WELWYN HATFIELD COUNCIL – DEVELOPMENT CONTROL
DELEGATED REPORT

APPLICATION No:	S6/2008/0907/FP
------------------------	------------------------

The application seeks permission to change the use of the Gatehouse from ancillary A3 use (restaurants, snack-bars and cafes) to A1 use (retail). Permission is not sought here for any works to the listed building.

DRAWING TITLE:
PROPOSED:
ELEVATIONS

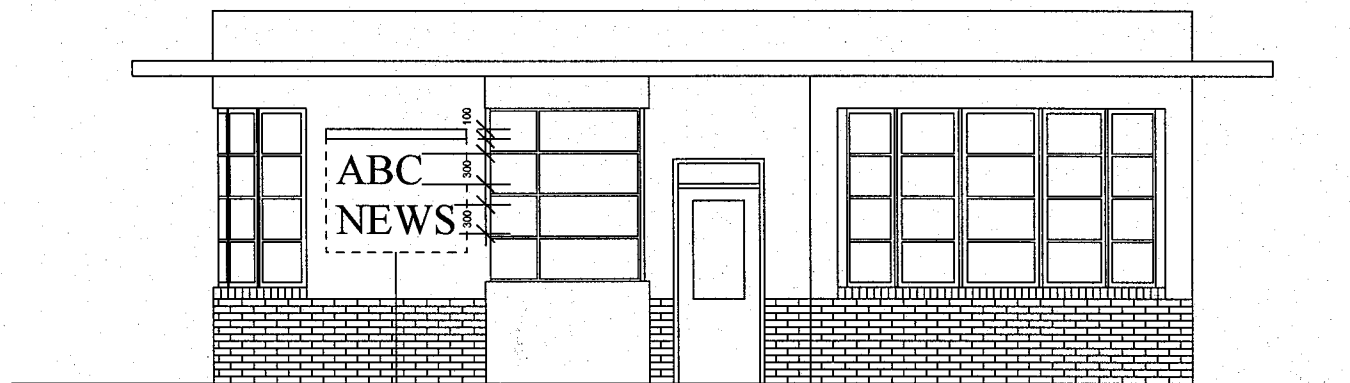
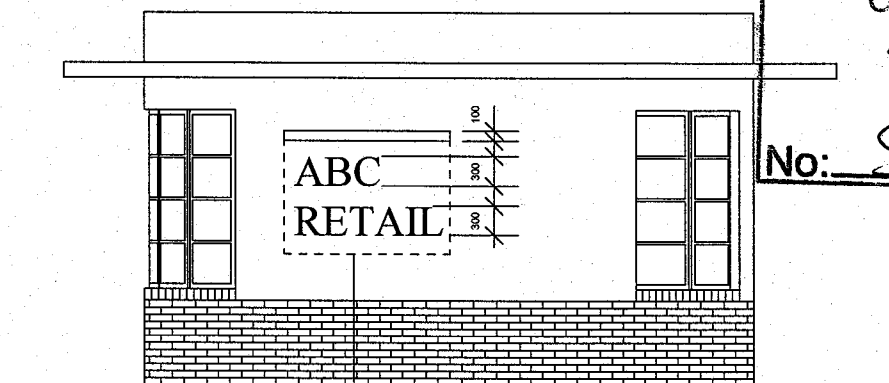
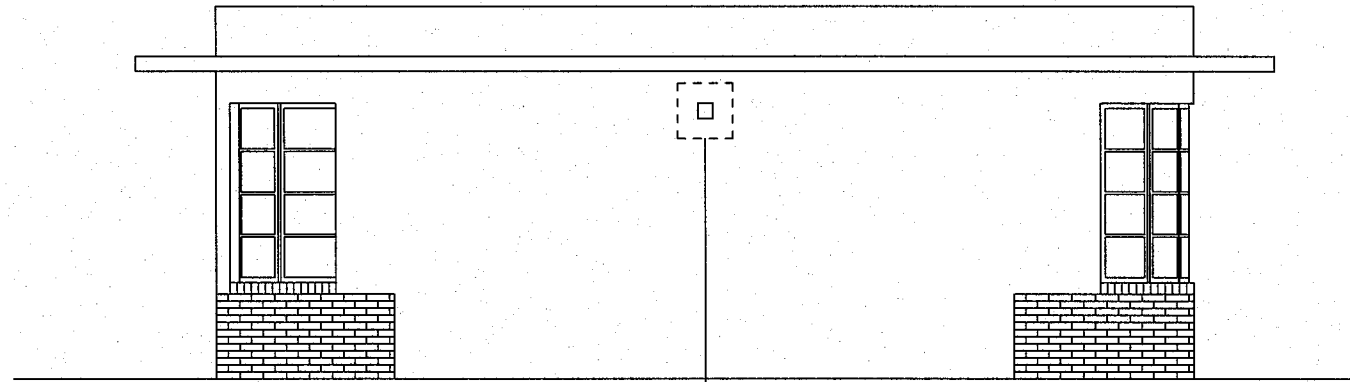
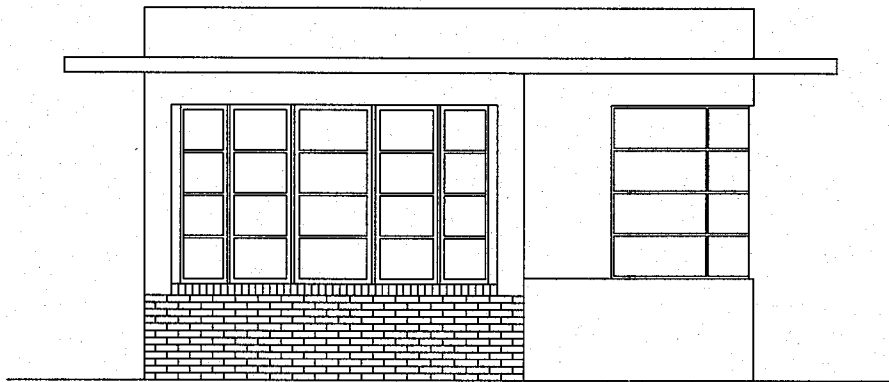
Drawing number A7.1 (proposed elevations) shows an indicative sign on external elevation of the Gatehouse. The plan states that this sign will comprise of pin mounted letters, which will be externally illuminated using trough lit illumination. The plan also confirms that the signage details will be confirmed by the future operator. Applications will therefore need to be submitted by the applicant for advertisement consent and listed building consent at a later date. These applications will need to demonstrate that the proposed signage is in keeping with the 1930s Art Deco style of the listed Gatehouse building and should respect the character and setting of the building.
